Addendum No. 1

RE: Contract # C204876

Rockingham County (BR-0095)

BRIDGE #170 OVER US-220 ON SR-1360

TRAFFIC CONTROL DETAILS

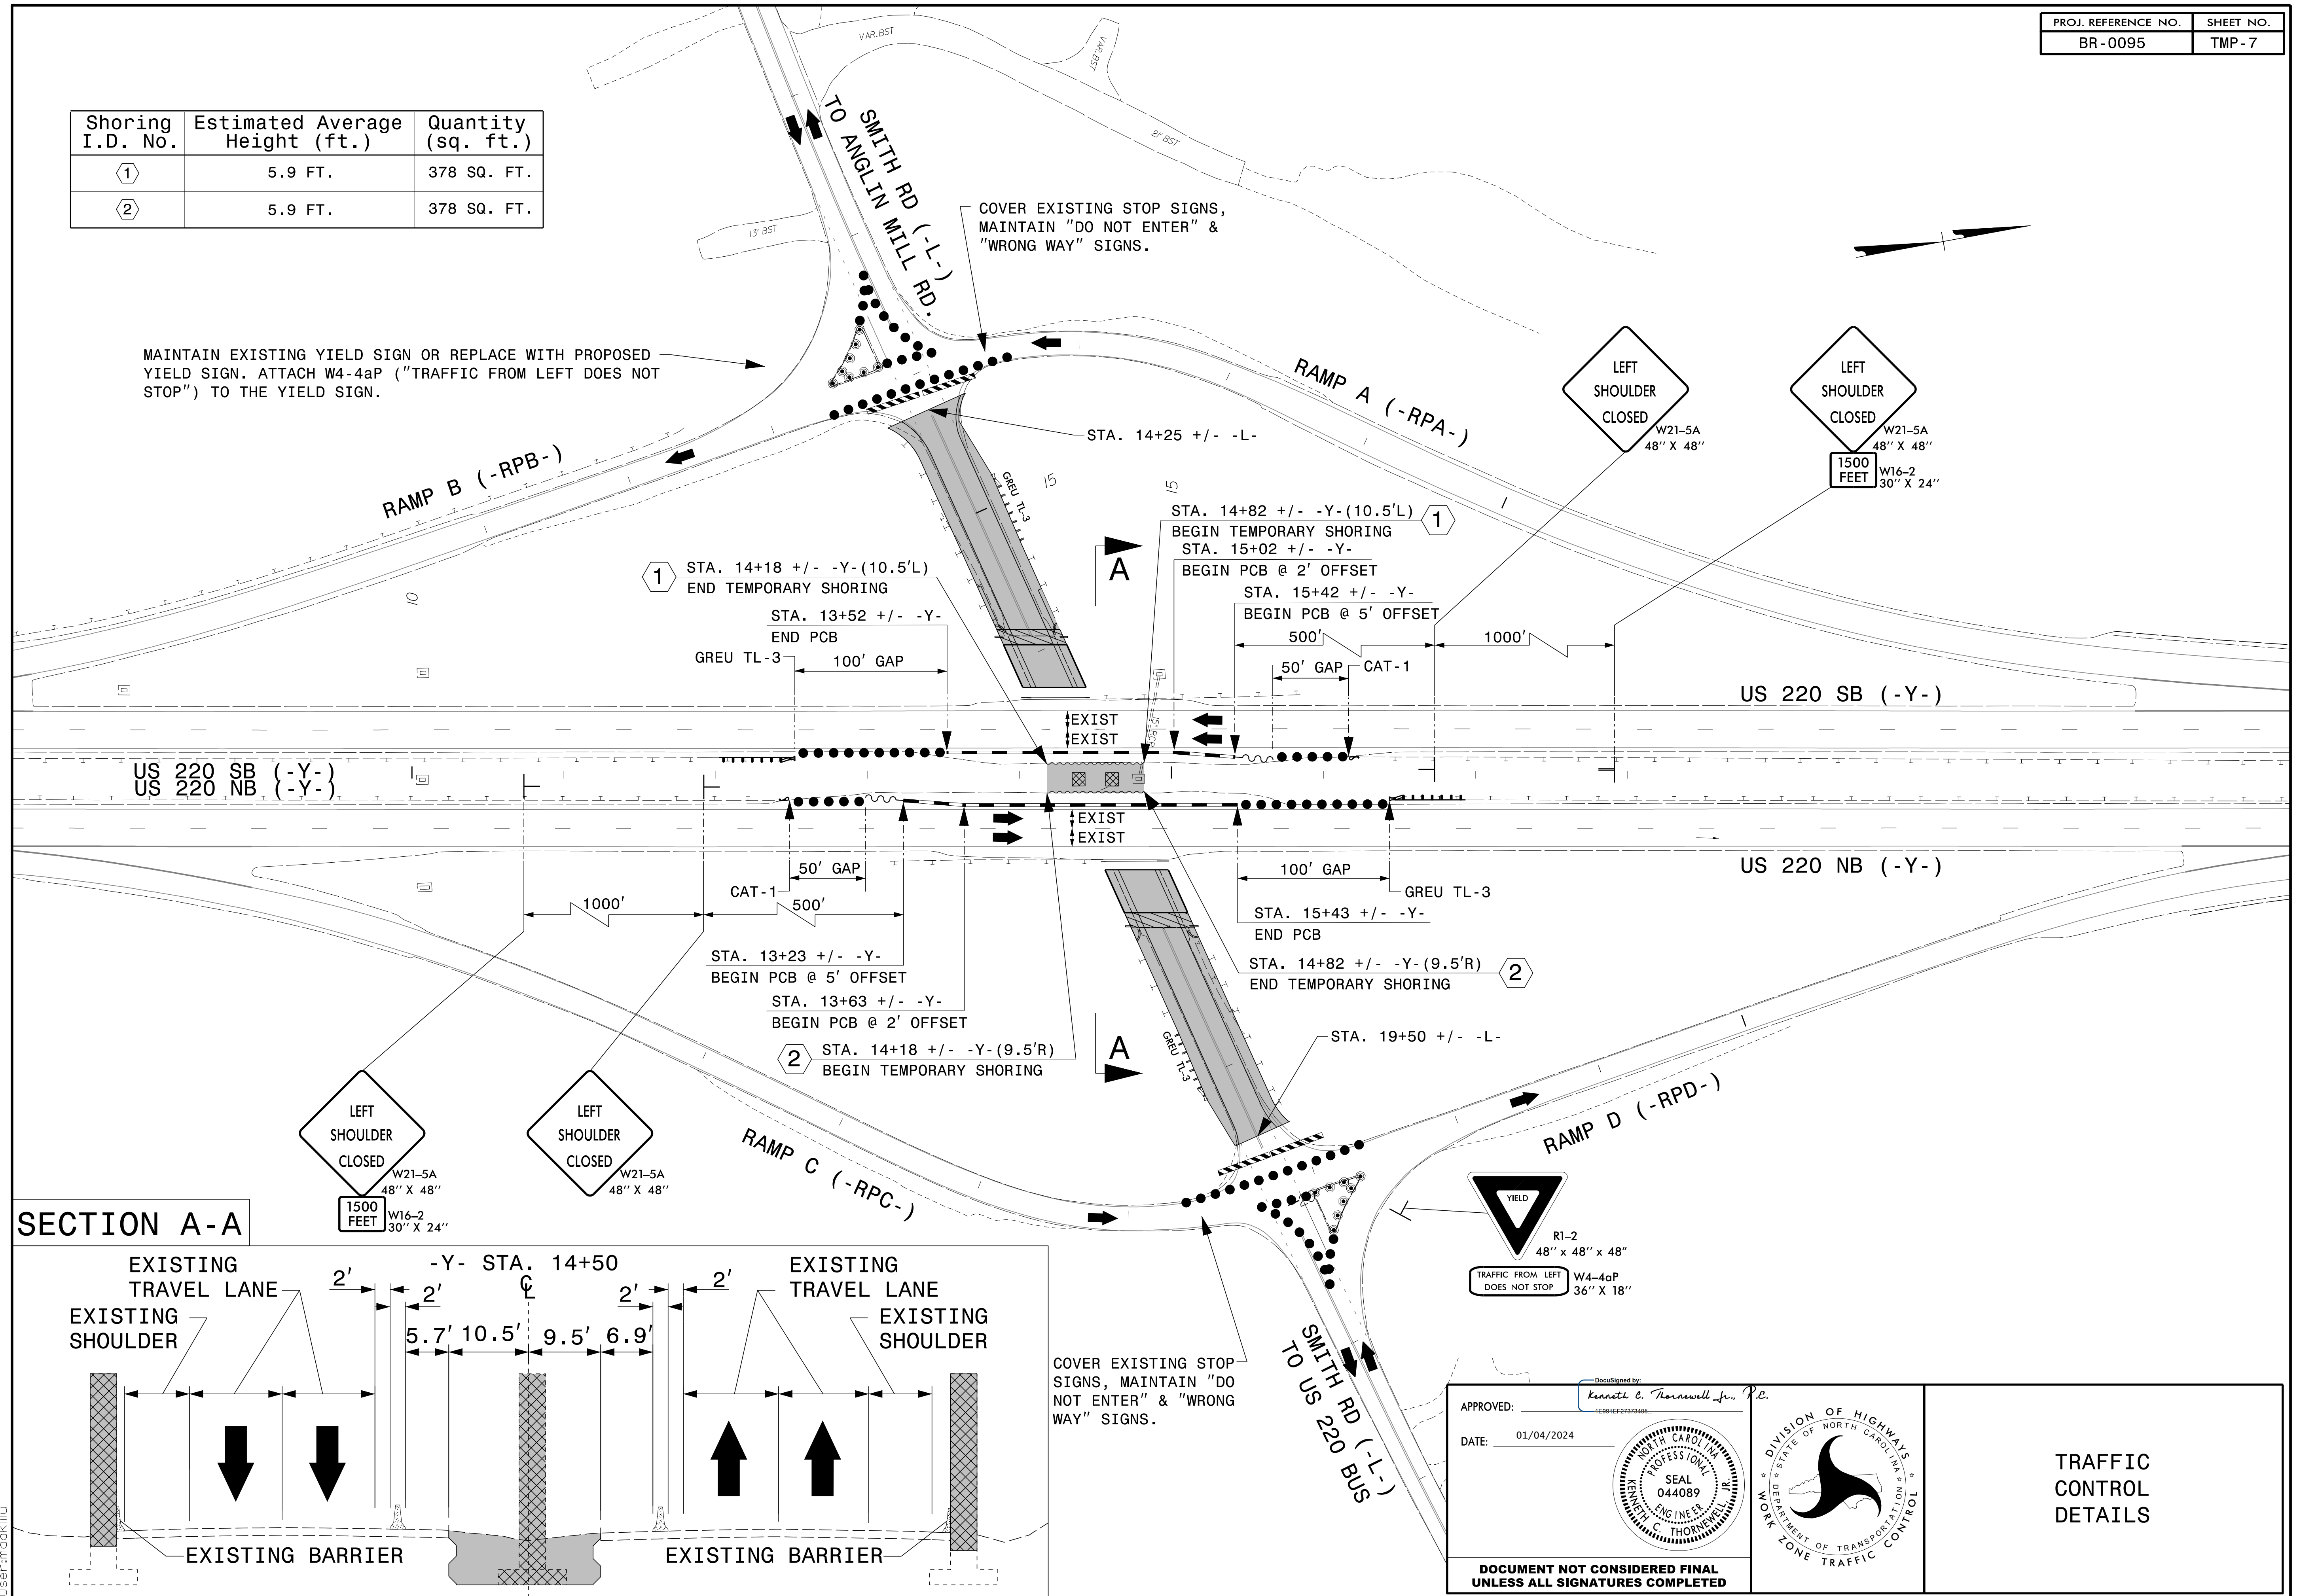
Sheet No.	Revision
TMP-2A	New note added to top of plan sheet.

THE CONTRACTOR IS ADVISED THAT THE TEMPORARY SHORING SHOWN ON SHEET NO. TMP-7 OF THE TRANSPORTATION MANAGEMENT PLANS FOR BRIDGE CONSTRUCTION WILL INTERFERE WITH TWO EXISTING RCPs. THE CONTRACTOR SHOULD DESIGN THE TEMPORARY SHORING TO AVOID DAMAGE TO THESE TWO RCPs AND THE CONNECTING BOX.
